CITY OF ALBUQUERQUE

April 24, 2020

**RE: Stanford Townhomes
424 Stanford Dr. SE
Revised Grading and Drainage Plan
Engineer's Stamp Date: 04/21/20
Hydrology File: K16D084**

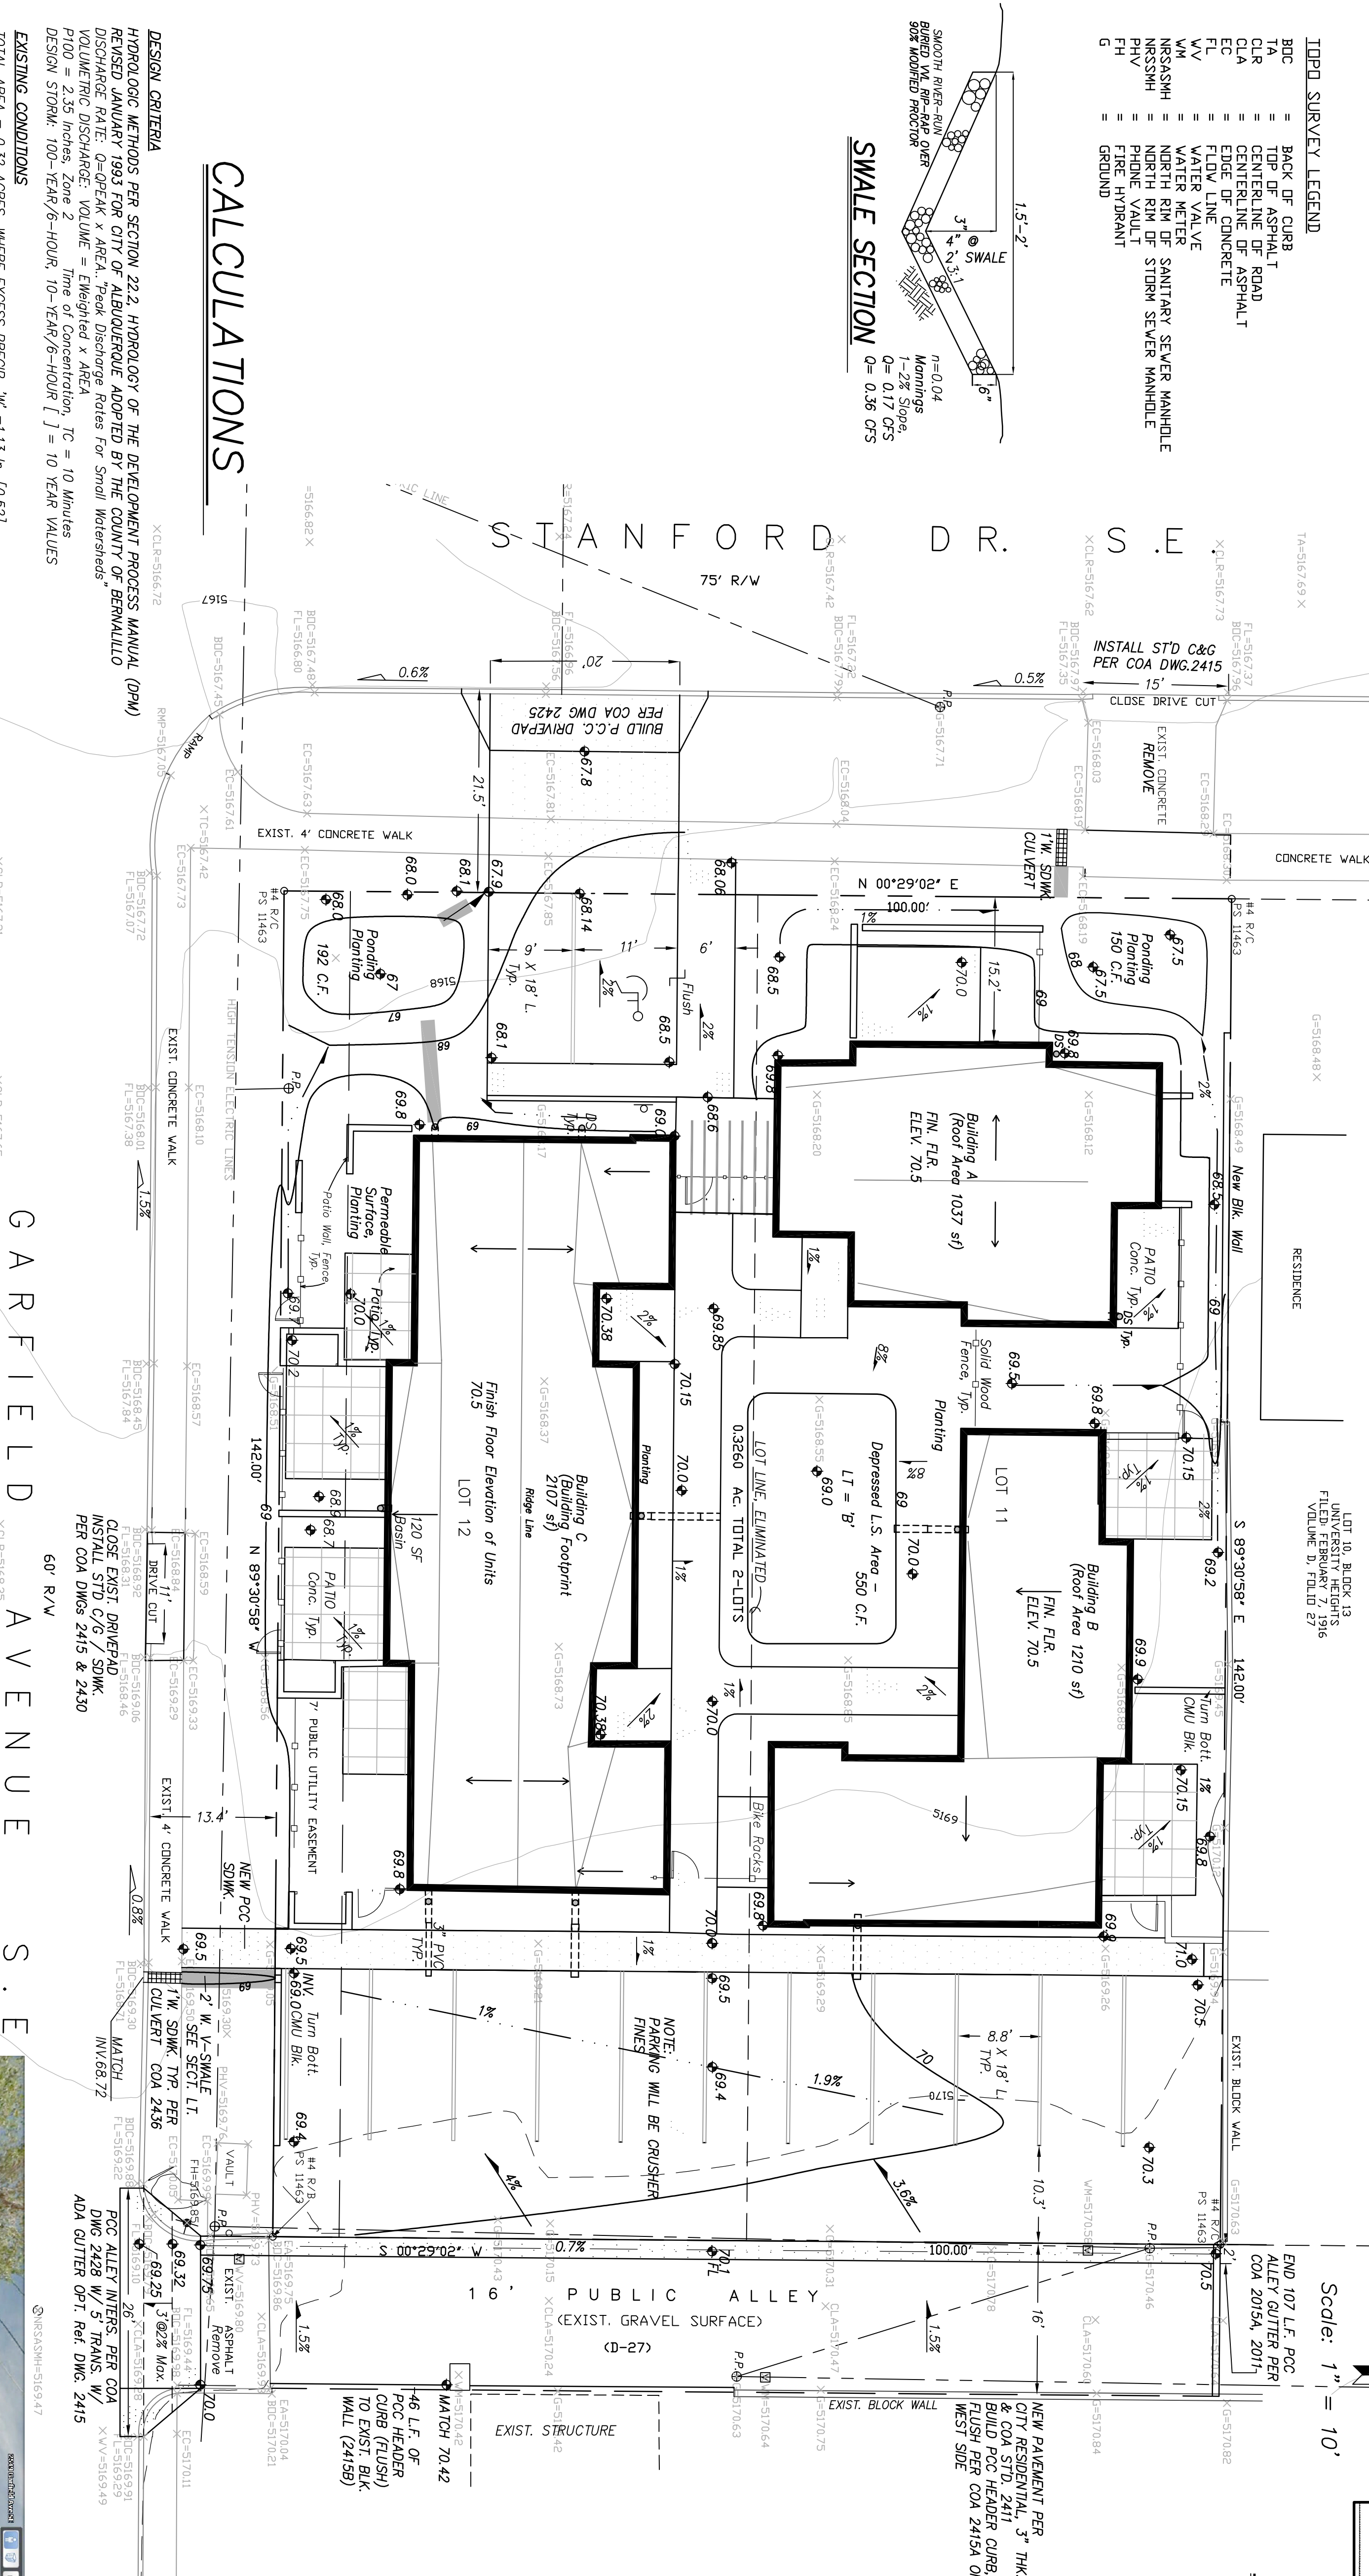
1. Please use the drafting standards outlined in the DPM. Plans need to be black & white with appropriate line weights for existing and proposed items. Color plans are very hard to read.

2. Please remove all interior architecture items for the townhomes. One it's not needed and secondly it is hard to read the finish floor elevation.
3. Please provide the FIRM Map and floodplain note with effective date.

4. The two stormwater quality ponds along Stanford Dr. need an emergency spillway. This can be done with a sidewalk culvert. Just make the invert elevation on the pond side the same elevations as the water surface elevation of the required SWQ volume. Also you can only use one sidewalk culvert if you connect the two ponds with a pvc pipe under the private sidewalk.

5. For the sidewalk culverts, instead of the orifice equation which was used, the broad crest weir equation (equation 6.60 in the DPM) must be used, not the orifice equation. A coefficient of 2.7 is typically used for the equation $Q = CLH^{2/3}$.

6. Please update the SO-19 Permit Notes. See Attachment.
